Re: Proposed Various Extensions and Detached Garage.

At: 20 Wilthorpe Farm Road, Wilthorpe, Barnsley. S75 1ES.

Application No: 2009 / 1563. Application Date: 7th. December 2009.

TITLE Location & Site Layouts

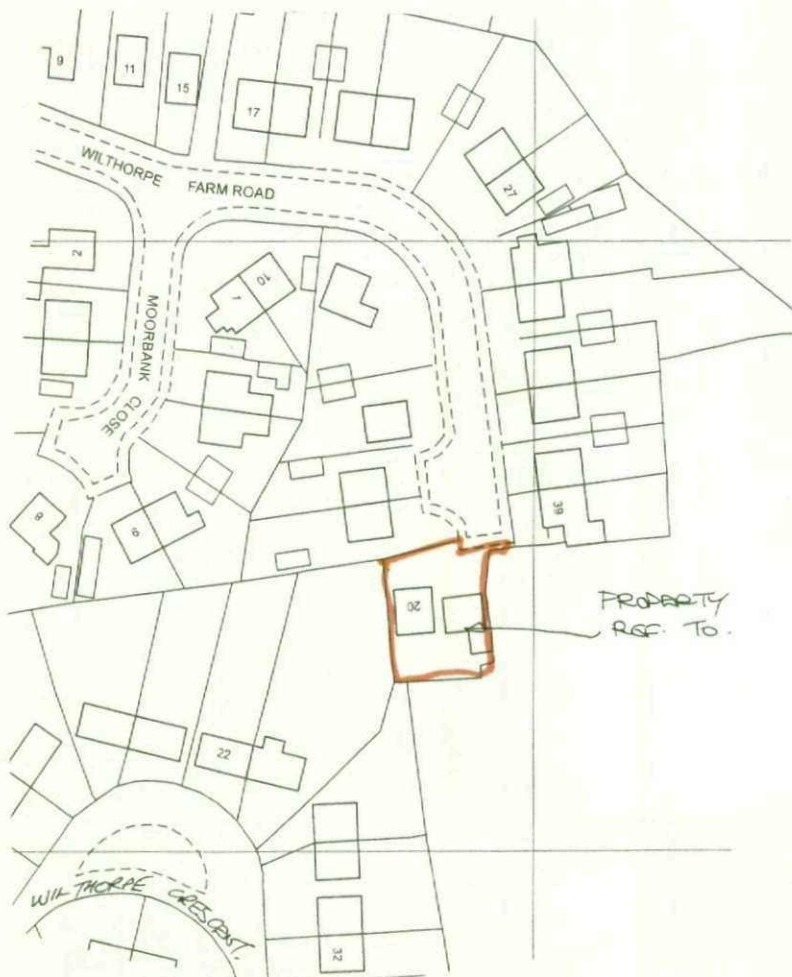
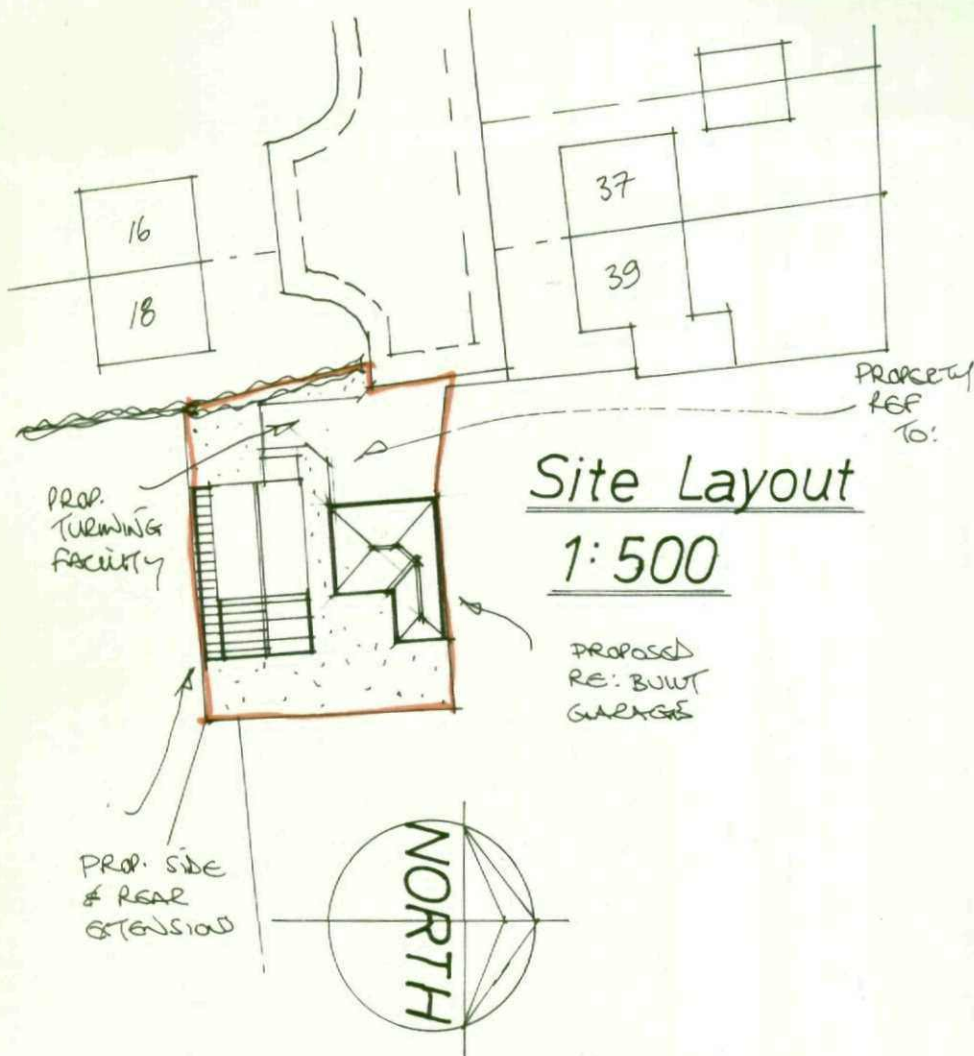
Also find copies of the Site and Location plans, amended accordingly as requested.

PROJECT Various Extensions
 CLIENT Mr. G. Heppenstall
 TITLE Detached Double Garage
 ADDRESS 20 Willthorpe Farm Road, Willthorpe, Barnsley. S75 1ES.
 DRAWN BY ggg
 SCALE 1:50; 1:100 DATE Dec.09
 DRAWING No 717-04 REV
 Member of the Chartered Institute of Architectural Technologists

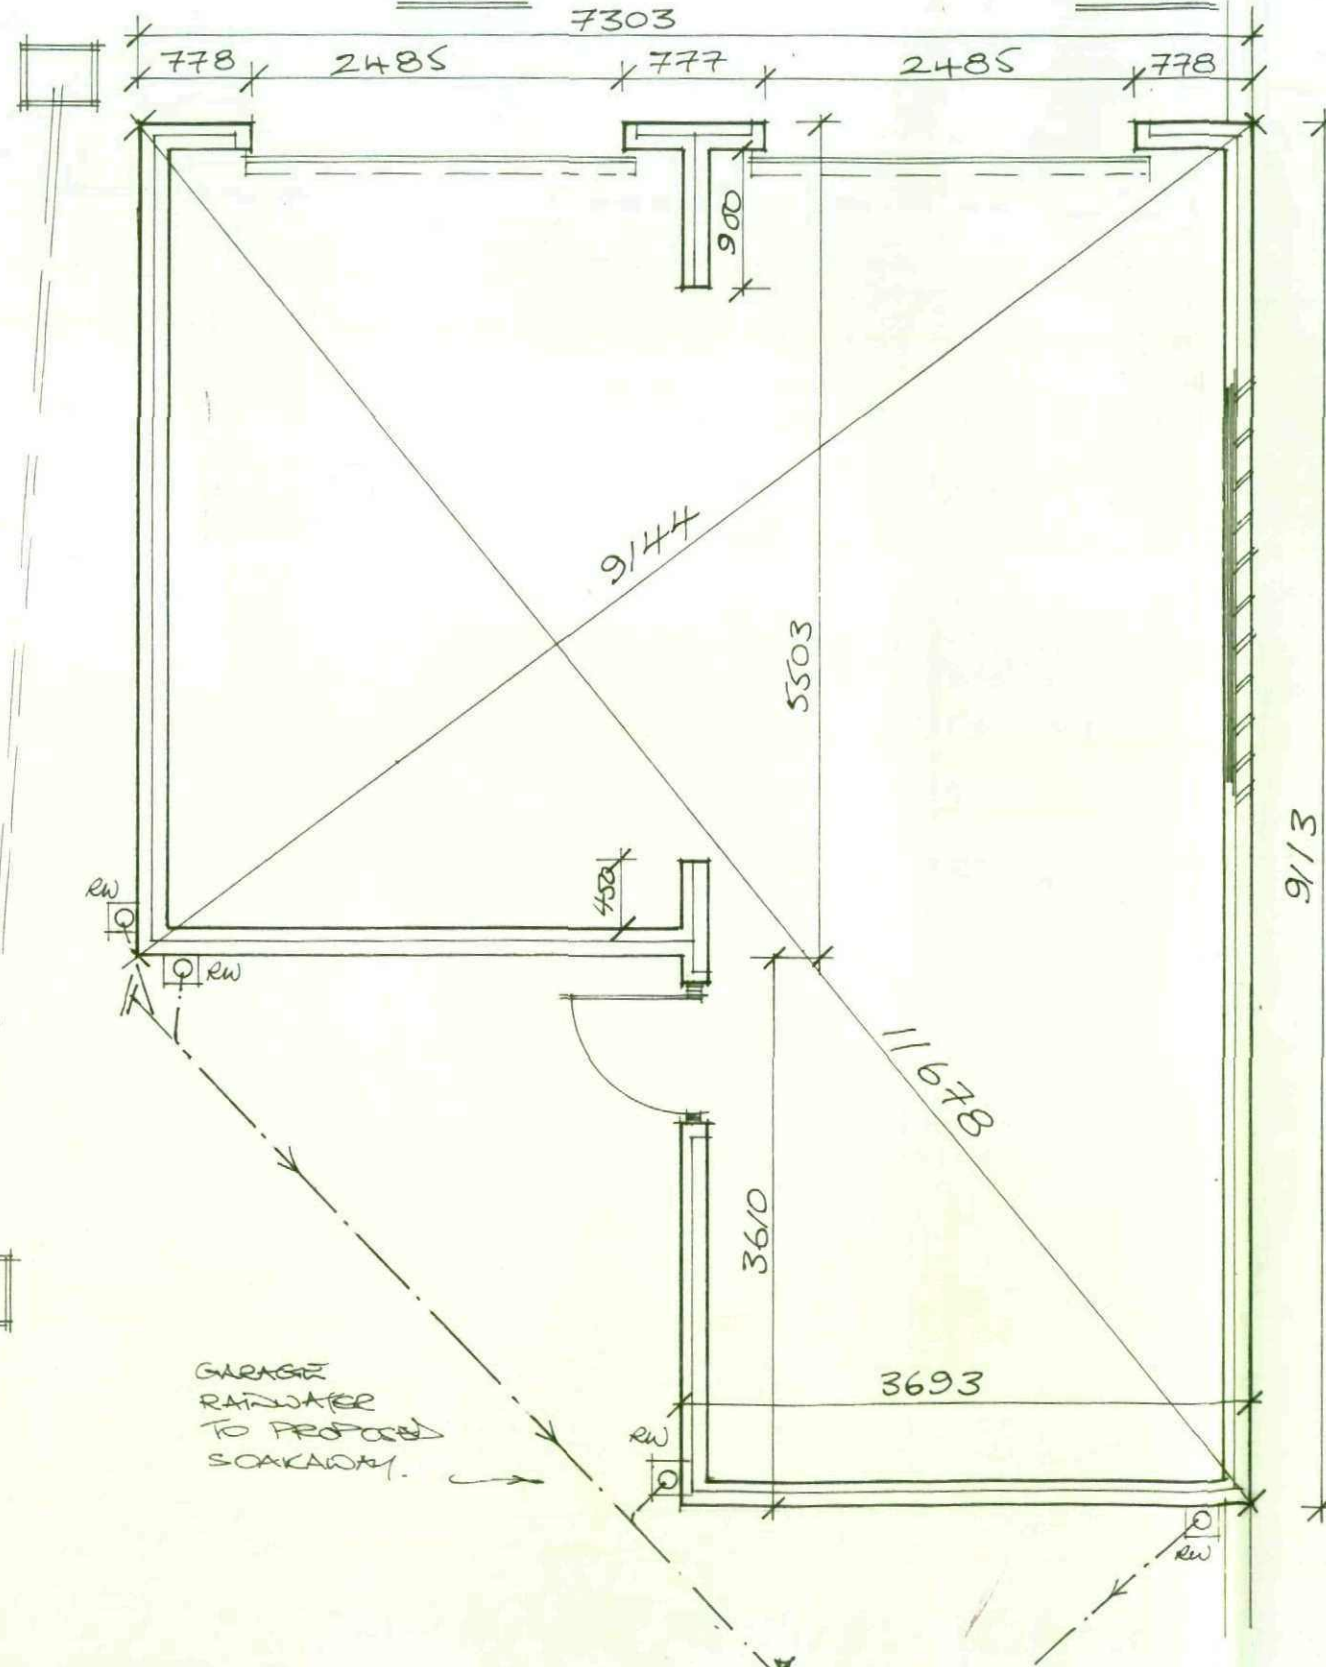
Further to your recent site visit and subsequent conversation with ourselves, please find attached 3 No. copies of information as listed below now amended hopefully to your requirements, namely the reduction of the rear elongated part of the detached - garage.
